**App No:** CM/37/18/OUT

**Address:** Mistletoe Farm Horsemere Green Lane Climping BN17 5QZ

**Proposal:** Outline application with some matters reserved for the redevelopment of site with 2 no. 4-bed detached bungalows & associated works (resubmission following CM/10/18/OUT). This application is a Departure from the Development Plan.

proposed block plan 1:500@A3

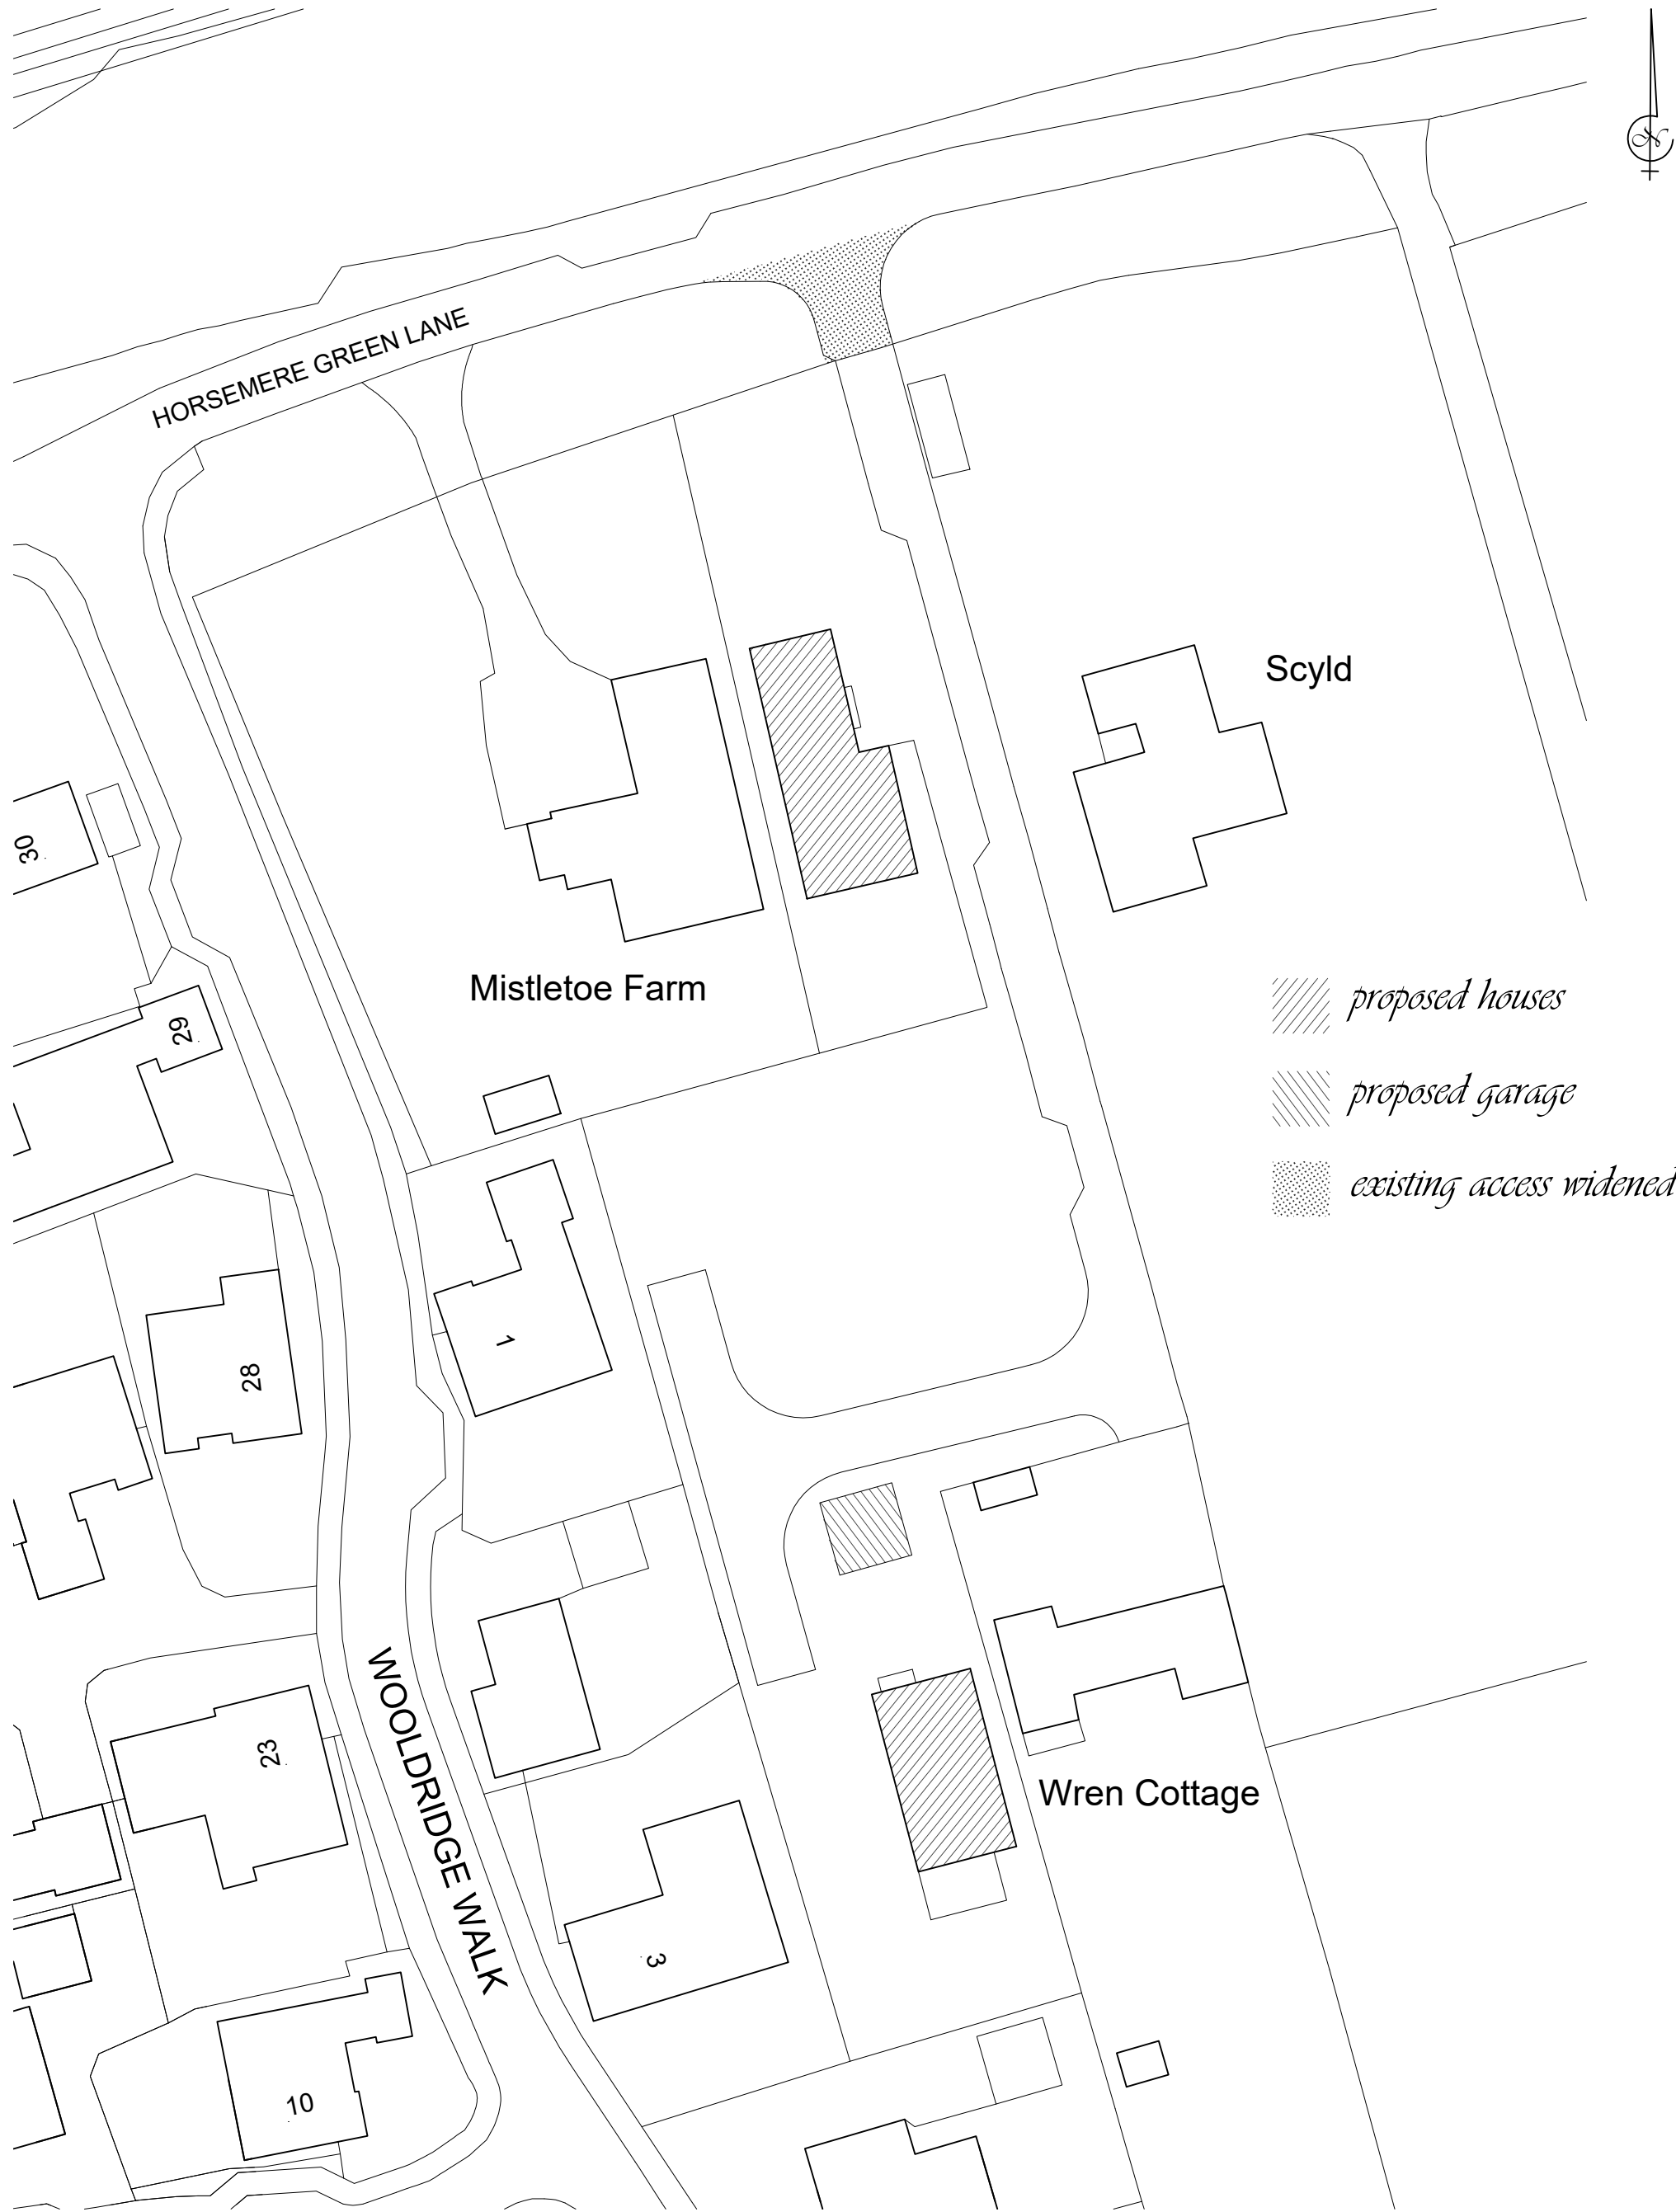
Due to the potential for roosting bats within tree T38, this tree must be retained and protected during the construction works. If this is not possible then further bat surveys on this tree would be required.

The lighting scheme for the site will need to take into consideration the presence of bats in the local area and the scheme should minimise potential impacts to any bats using the trees, hedgerows and buildings by avoiding unnecessary artificial light spill through the use of directional light sources and shielding.
